***Centre for Obesity, Diabetes and  
Cardiovascular Disease,  
The University of Sydney***

***MP 09\_0051 MOD 2 – Modification to the  
design of the approved CODCD building***

Director-General's  
Environmental Assessment Report  
Section 75W of the  
*Environmental Planning and Assessment Act 1979*

March 2012

Building Alignments

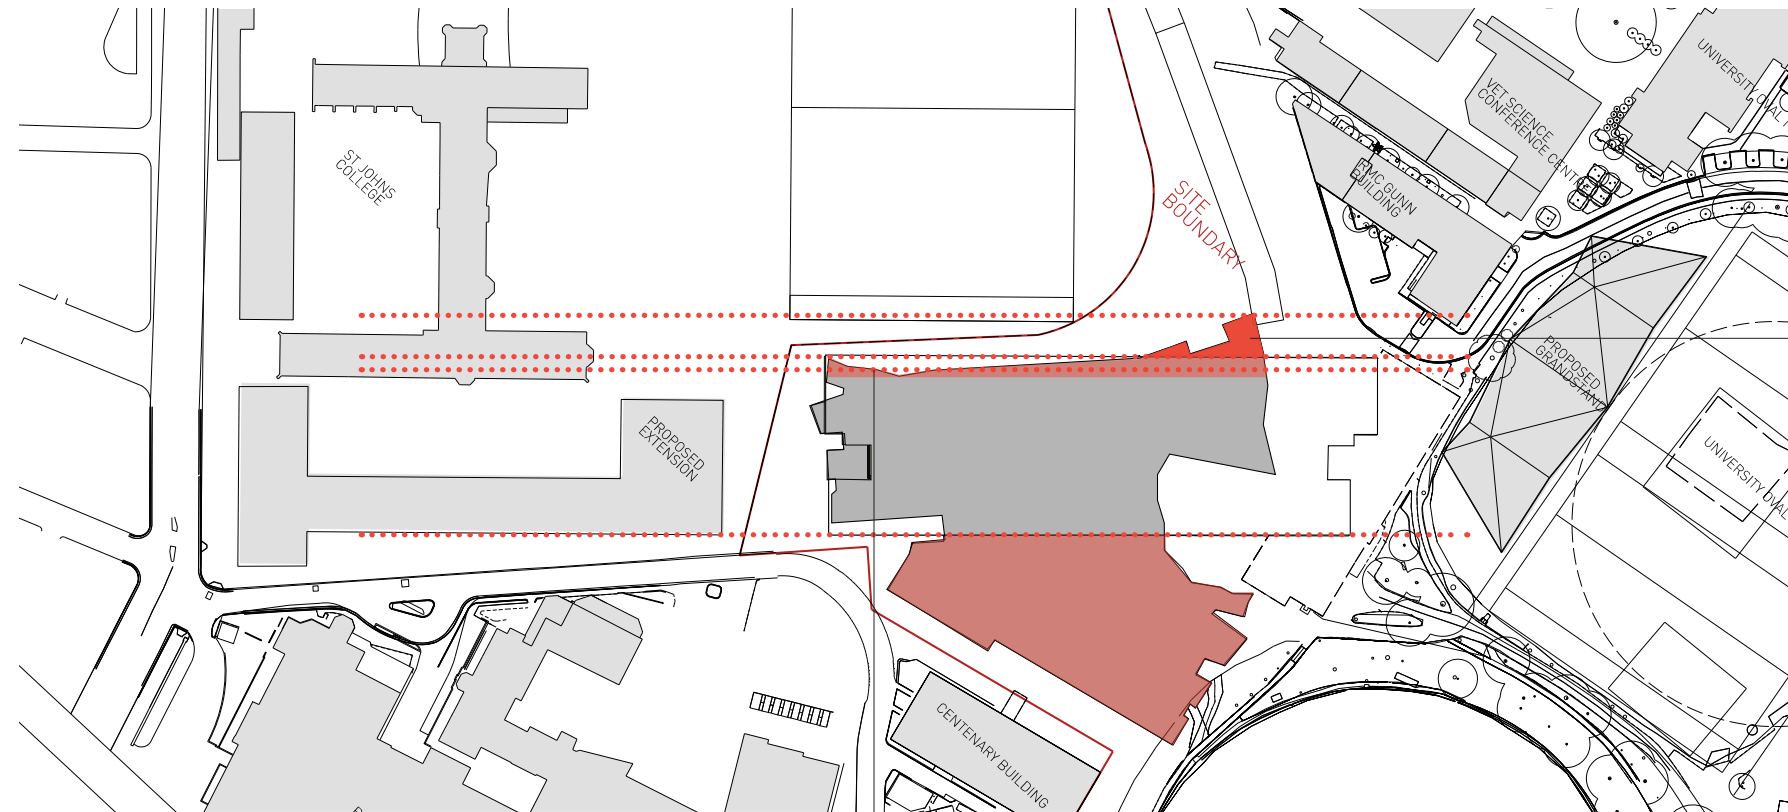
The modified building will be within the view arc of St John's College. **Appendix E** shows the view corridor identified in the original CMP 2001 extending from the north-west to the north-east. Council advise the northern façade does not follow the alignment of the southern wing of St John's College identified as an important view corridor in the CMP 2001. Further, Council advise while

neither the approved or modified scheme matched this alignment, the modification application presents an opportunity to reduce the heritage impacts of this development.

- the proposed setback of the building alignment of the ground and first floor level in the corner locations, creates a view corridor not previously available (as approved and or modified in the context of the amended CMP for St John's College) along the northern elevation to St Johns College;

- the further encroachment of the building beyond the projected alignment of the southernmost wall of St Johns College is limited to the upper levels (level 3 to parapet) where pedestrian views of the local heritage item are unavailable and will not result in additional impacts on the College Building;

Proposed North West Elevation

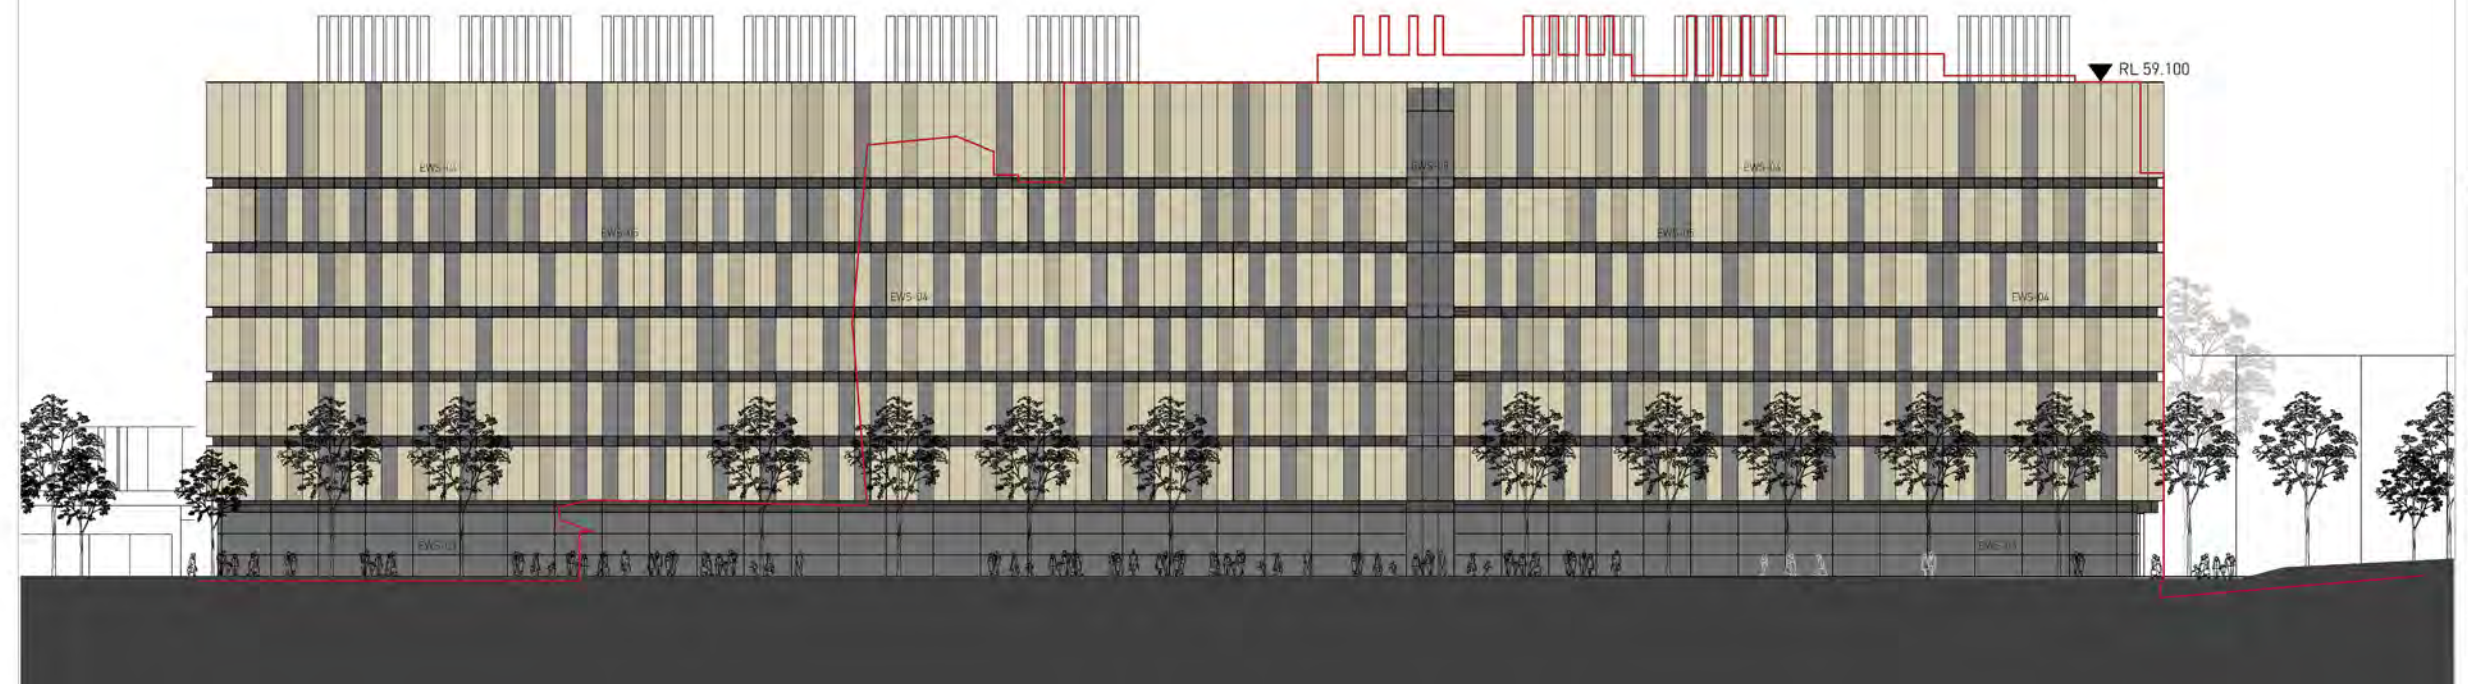
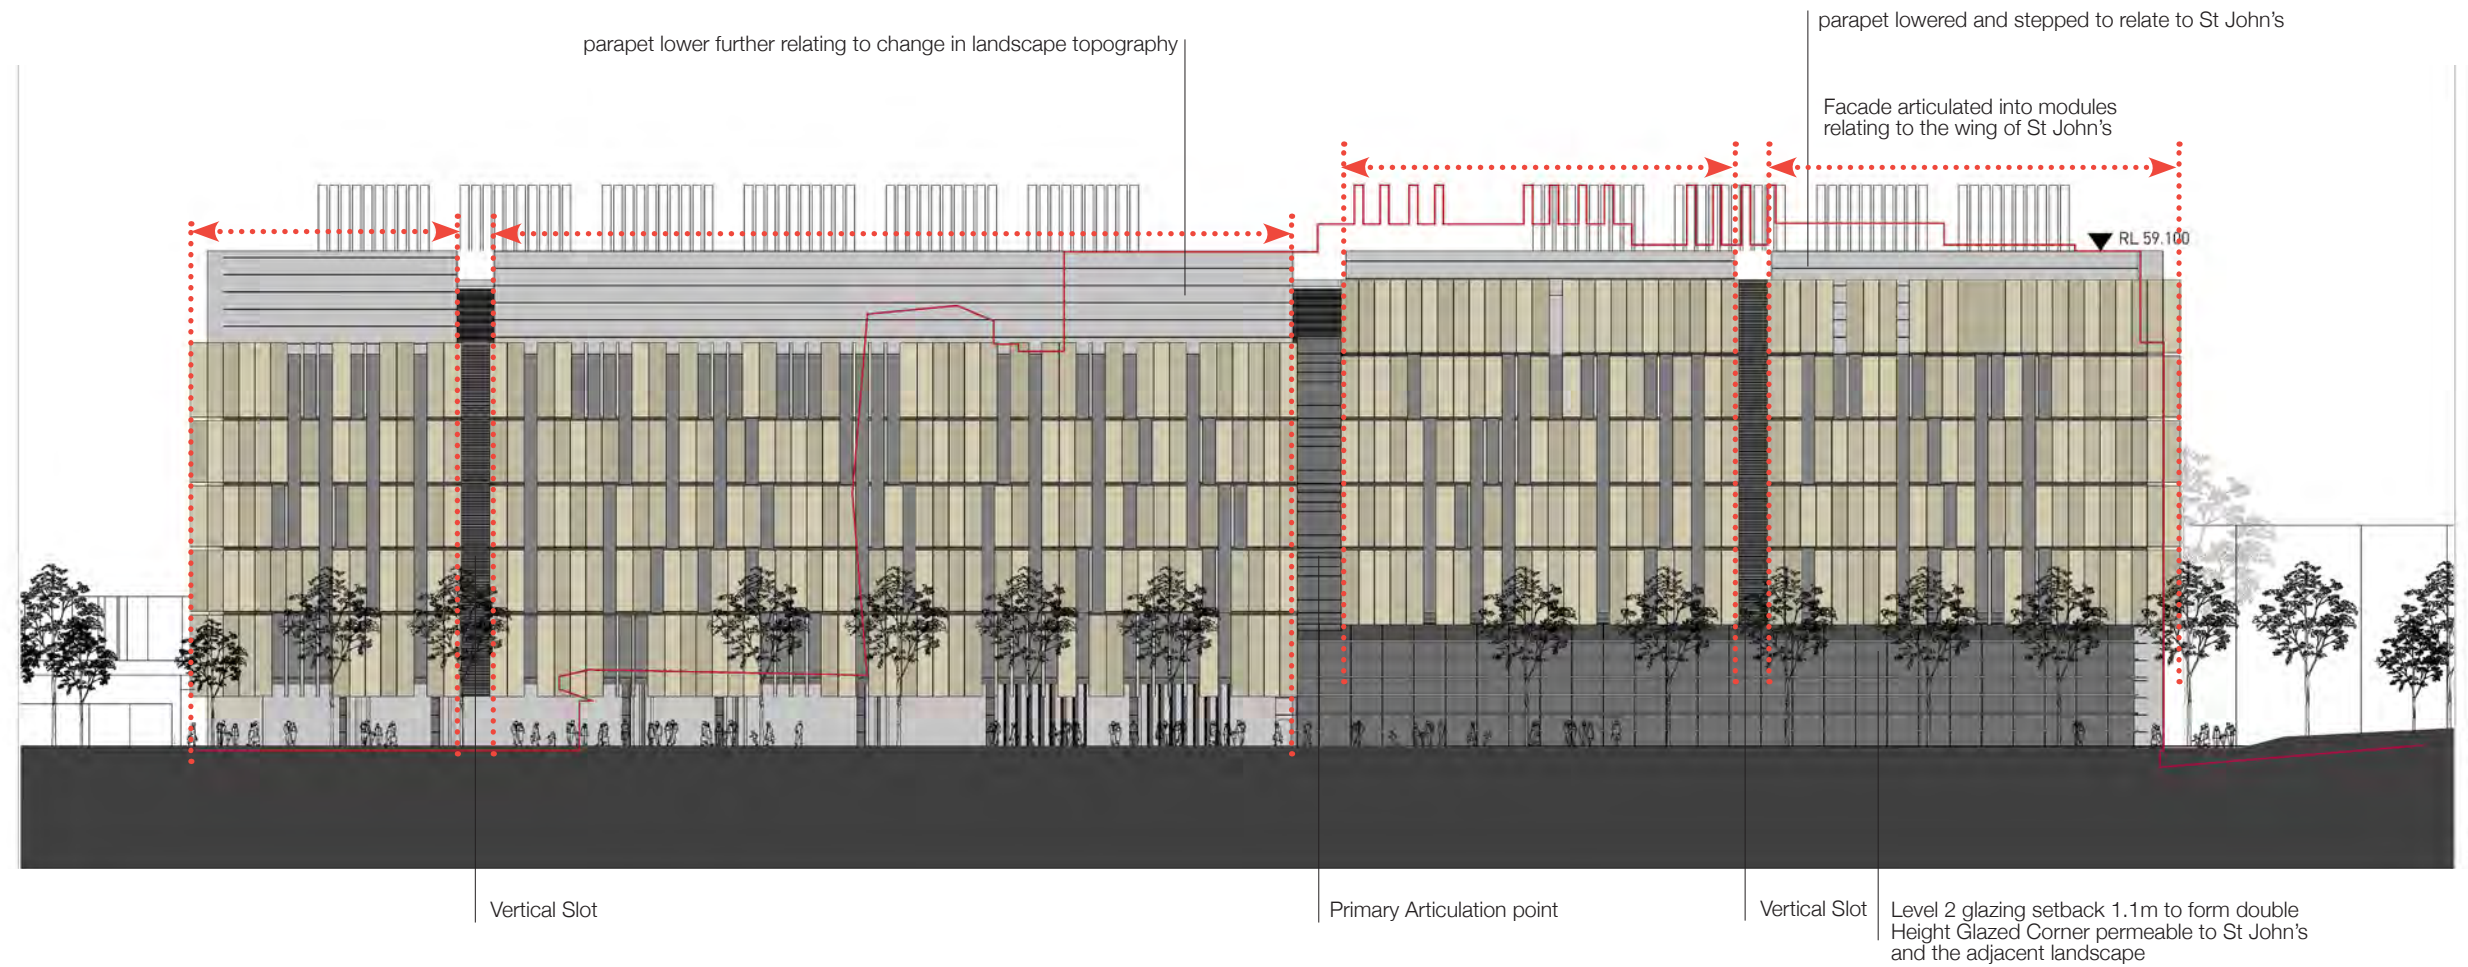
Council originally expressed that the building should not extend beyond the alignment of the southernmost wall of St John's College, consistent with comments made to both the original project and modified schemes as approved. In response, the proponent submitted amended plans (9 February 2012) to modify the north-west elevation to reduce the heritage impacts on the view corridor to St John's College.

Upon review of the amended plans, Council indicated a preference for the architectural expression of the northern façade in the original design. In particular, Council advised the amended scheme diminishes the strength and originality of the original design by its (different) proportions, the reduction in the size of the openings and reduced use of sandstone (solid to void relationship).

Council concluded that the original design is considered a more distinct response to this setting and more sympathetic to St John's College.

On 29 February 2012, the proponent advised they do not agree that the previous elevation successfully reduced the apparent bulk, given the sheer length of the building. To summarise, the proponent asserts the proposed revised design reduces the apparent length and height of the building and better relates to the College by further articulation of the north west corner. Further, the siting and variation in the façade design is consistent overall with the previous elevation that respects its specific context and beyond while retaining originality.

On balance, the department considers that the modified architectural expression to the composition and finishes to the northern façade are appropriate, noting that a combination of materials, delineation of the building into regular bays, stepped parapet height in response to the sloping topography and revised fenestration pattern provide an acceptable visual outcome, consistent with the façade treatment of that originally submitted. Further, the increased height of the ground plane recess (2 storeys in height), at the north west corner (closest to St John's College) of the northern façade, will reduce visual impacts and improve visibility of St John's College over this part of the site. The department also notes the improved relationship with adjacent heritage buildings by the additional articulation and revised fenestration.

The department is satisfied that the additional detailed design of the façade will not have any negative impacts and that the building retains a high design standard. On this basis, the changes are supported and the proposal should be accepted as amended (Refer to Figure 13).
